**EXHIBIT
BOUNDARY LINE ADJUSTMENT
KITITAS CO. TAX PARCEL NUMBERS 555035 & 565035**

Subject: Fraker Roulston Boundary Line Adjustment (BL-14-00020)

**EXHIBIT
BOUNDARY LINE ADJUSTMENT
KITITAS CO. TAX PARCEL NUMBERS 555035 & 565035**

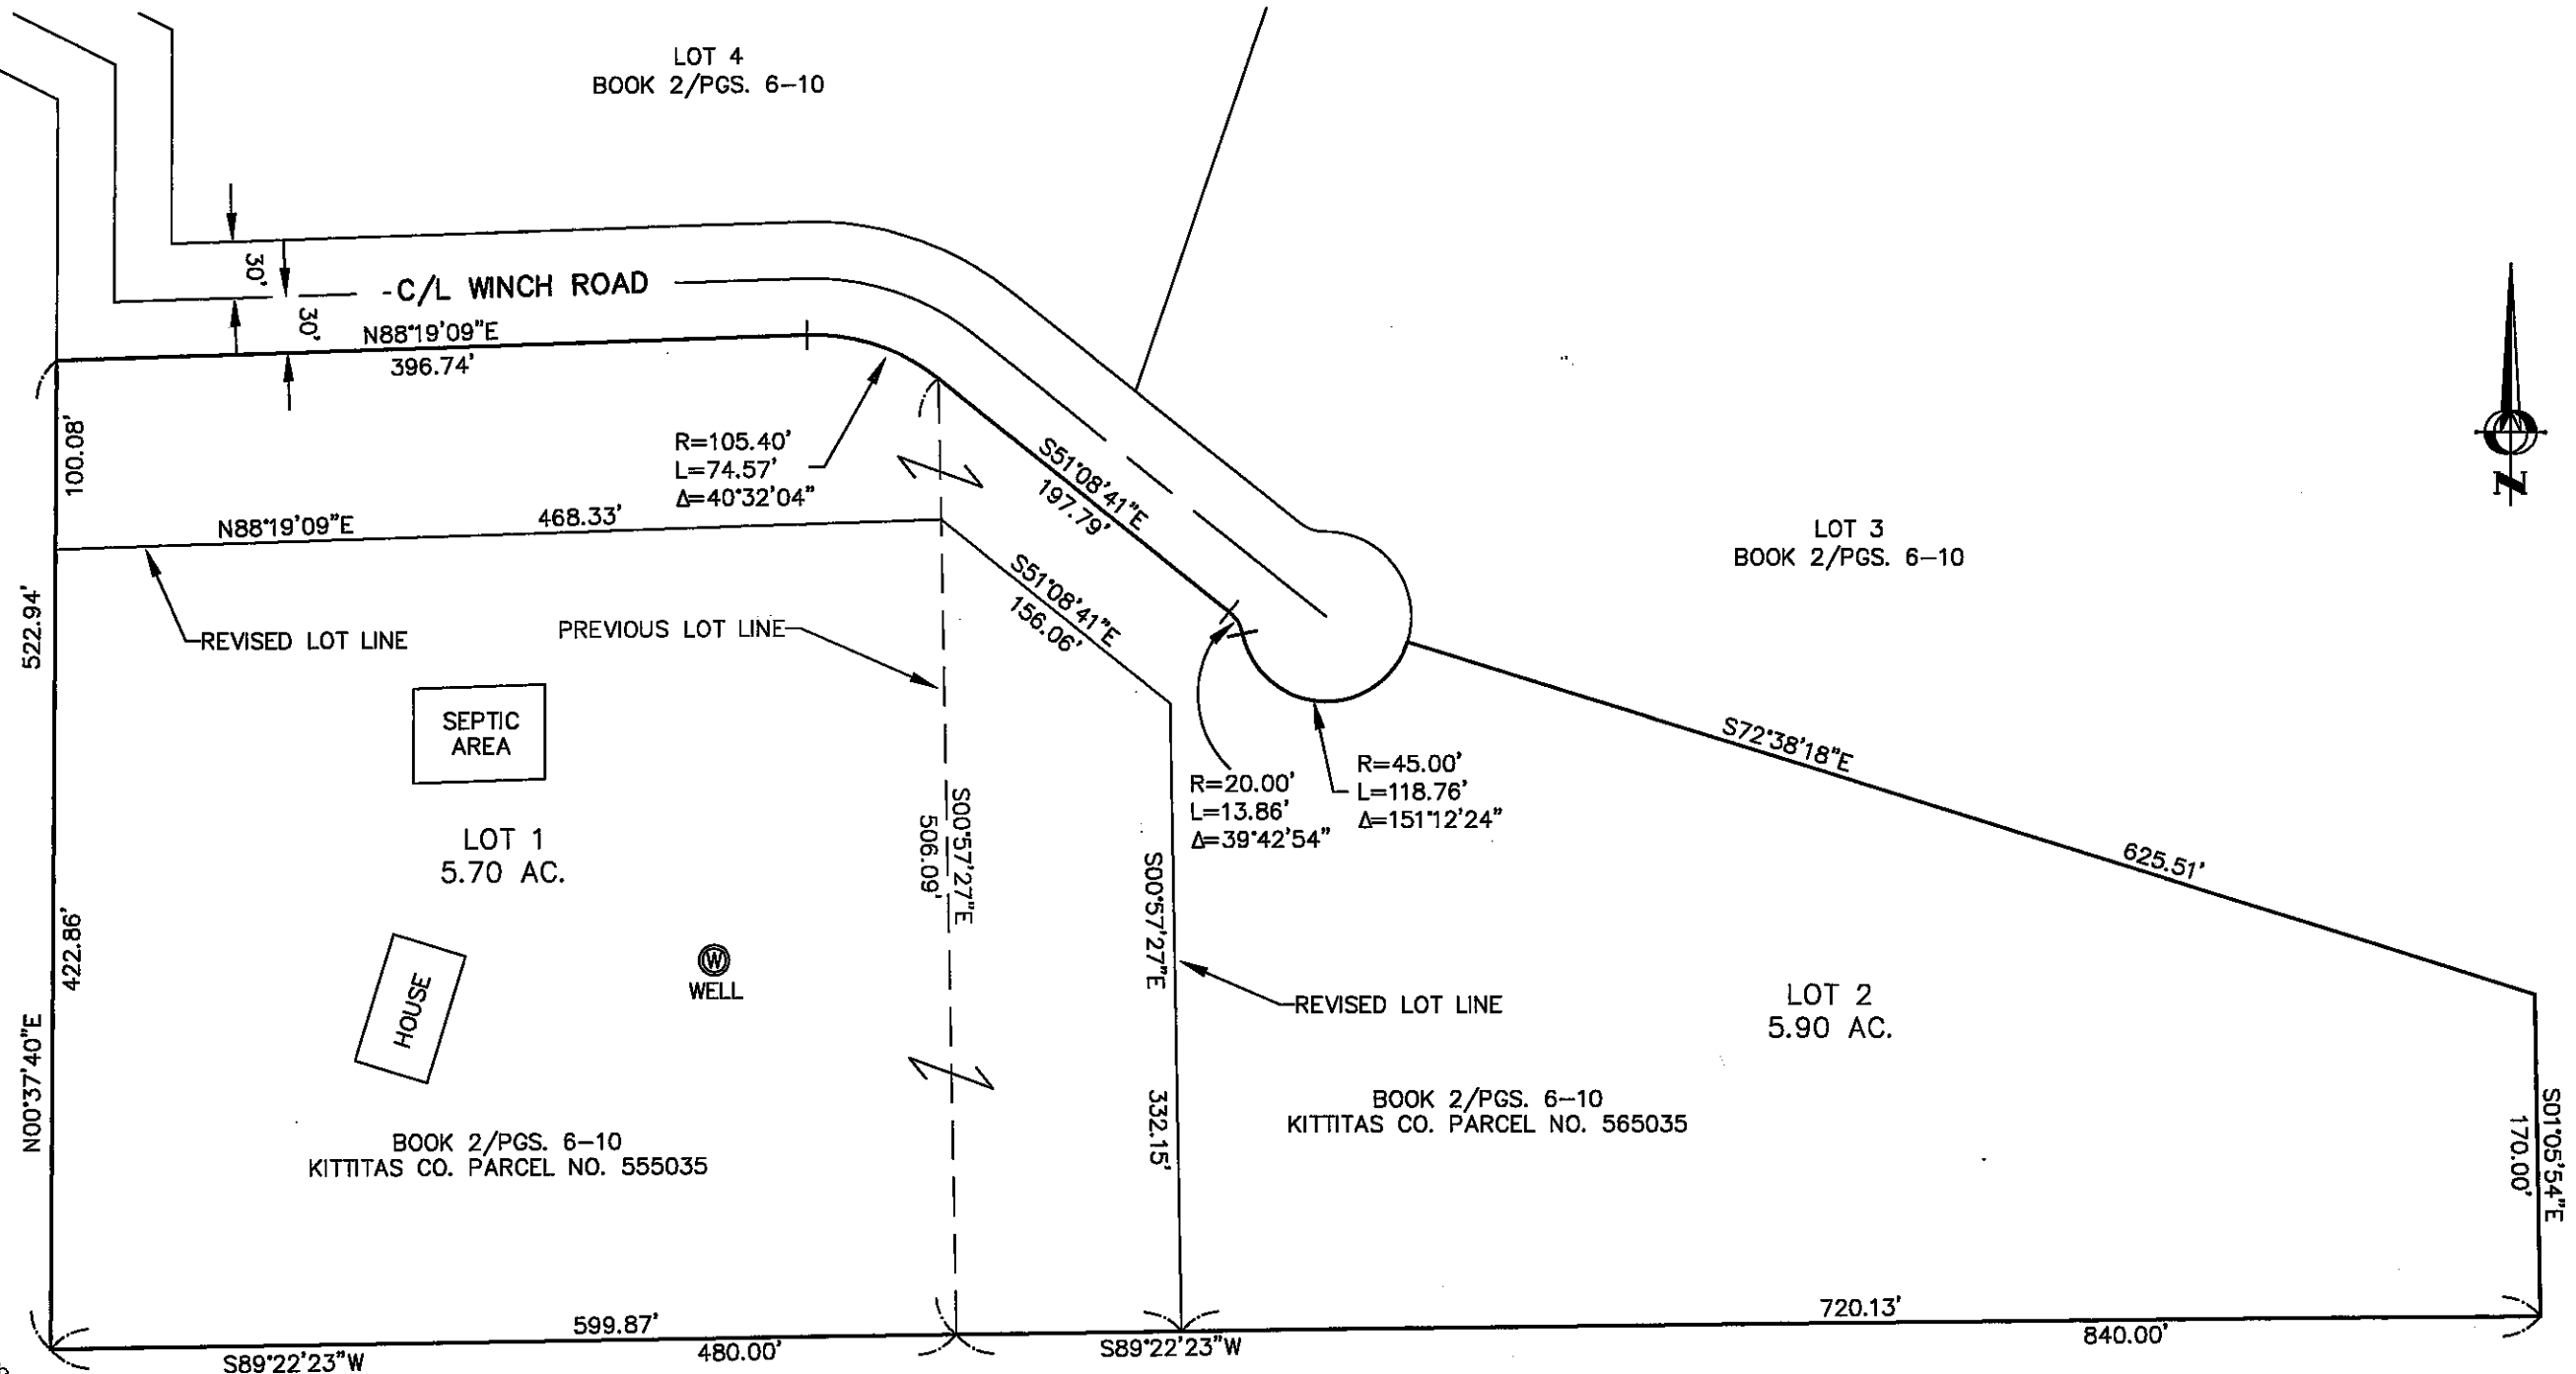
- *Location of Septic, Wells and all buildings on all parcels associated with Boundary Line Adjustment on a proposed and existing site plan.*
- *Project Narrative.*
